From: Contact Centre (CRM) <contact@ribblevalley.gov.uk>
Sent: 31 March 2026 23:42
To: Planning
Subject: Planning Application Comments - Application 3/2026/0171 FS-Case-820809353

Planning Application Reference No.: Application 3/2026/0171

Address of Development: 7 Hillside Drive, West Bradford

Client Mr and Mrs Thompson		
Project Retrospective Application for A Garden Gym at 7 Hillside Drive West Bradford BB7 4TG		
Drawing Title Proposed Plan, Site Plan and Elevations		
Scale 1:50/100/200 @ A2	Date Mar 2026	Drawn LFR
READ DESIGN LTD		
182 - 02

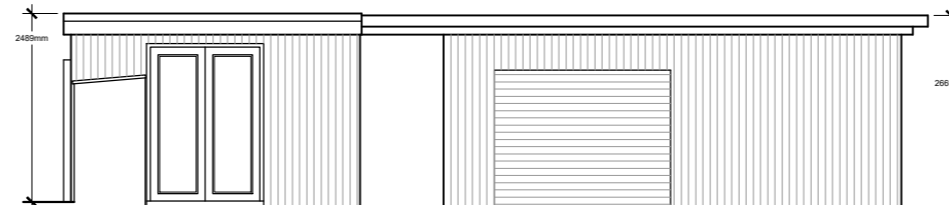
Comments: Please can it be ensured the proposed gym be clad all around the rear of the building along the wall running alongside the fence and the 2 end walls to be in keeping with the existing shed next door, to eradicate the blue painted metal of the shipping container.
